- Existing grade determination by code official
 - Existing grade is the grade established in the 2021 survey submitted with the building permit application - OR - the interpolated grade done by neighbors based on the conclusions of the out of date administrative interpretation:

- Existing rockery needs mitigation
 - Michele's original email in October:
 - Comment:
The geotechnical engineering report indicates "...due to the loose nature of the upper fill soils behind the rockery, it would only be considered moderately stable, and likely has a current factor of safety of 1.0 or slightly higher with regards to slope stability."

TOPOGRAPHIC & BOUNDARY SURVEY
 PARCEL NO. 9350900620
STRAND RESIDENCE
 6950 SE MAKER STREET
 MERCER ISLAND, WA 98040

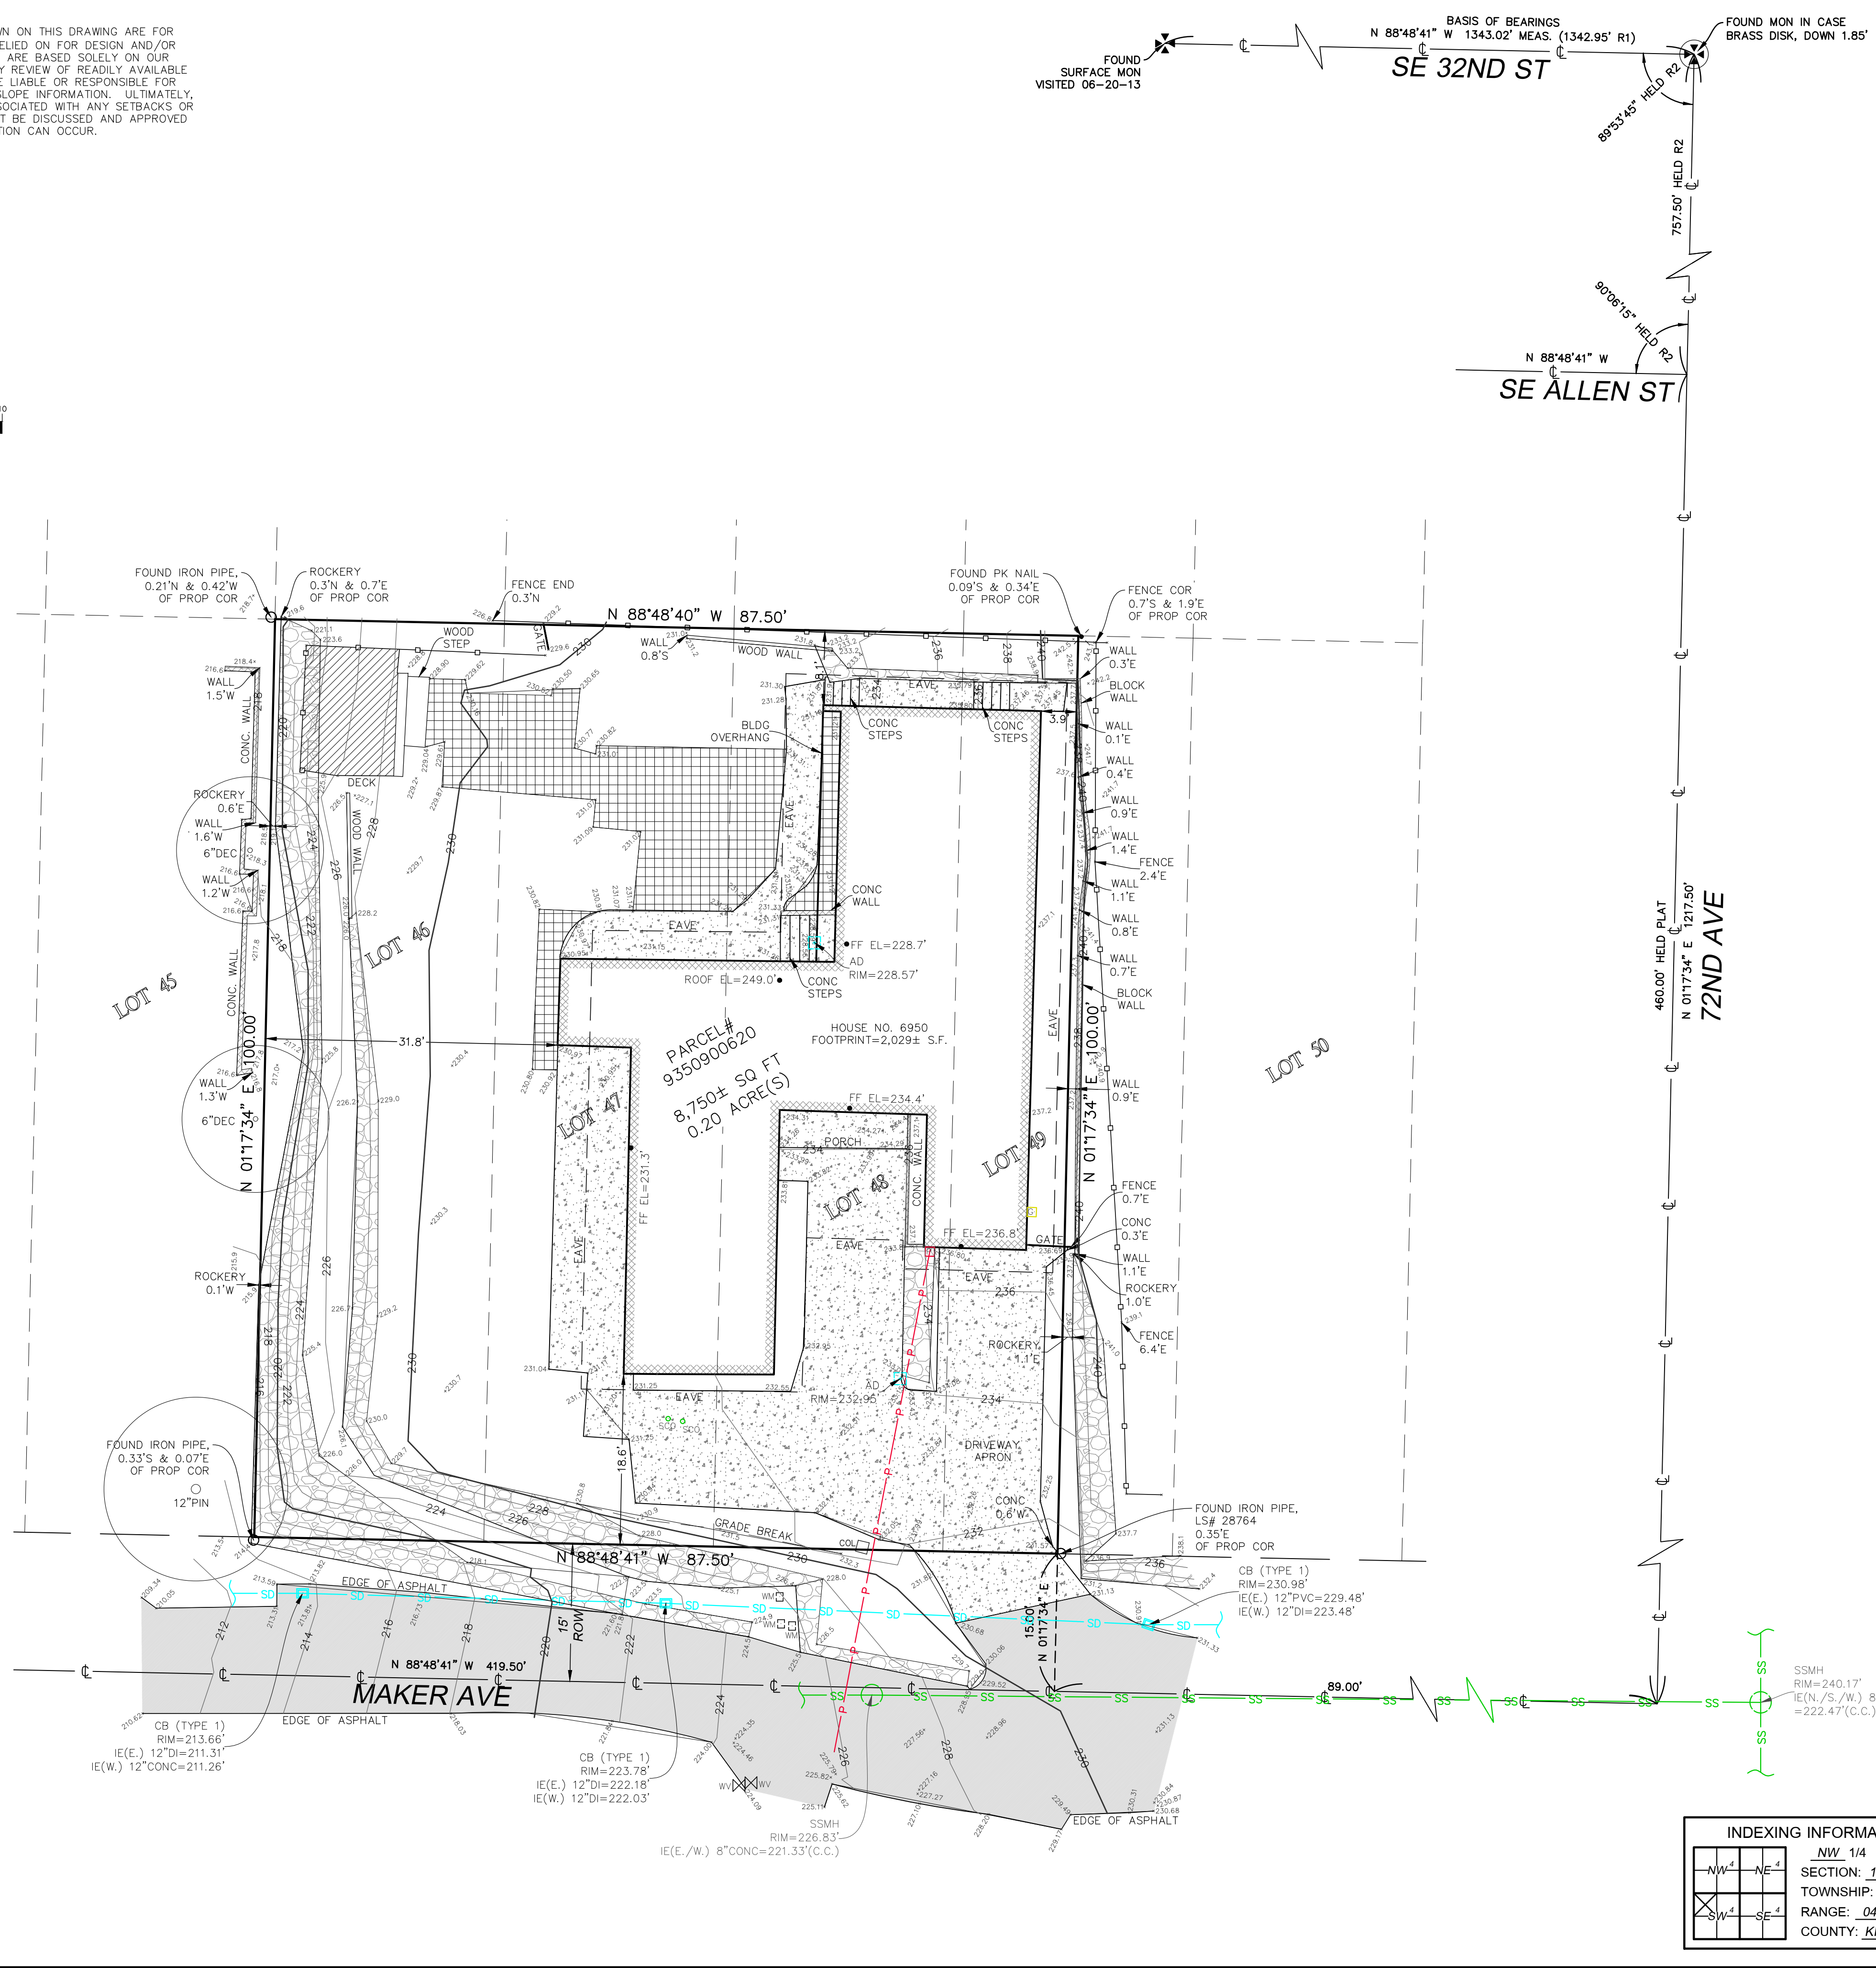
- No. 3 is based on whether or not there is a current survey available. The interpolated survey done by the neighbors is based on a survey from 1961 and an old survey for a neighboring property.
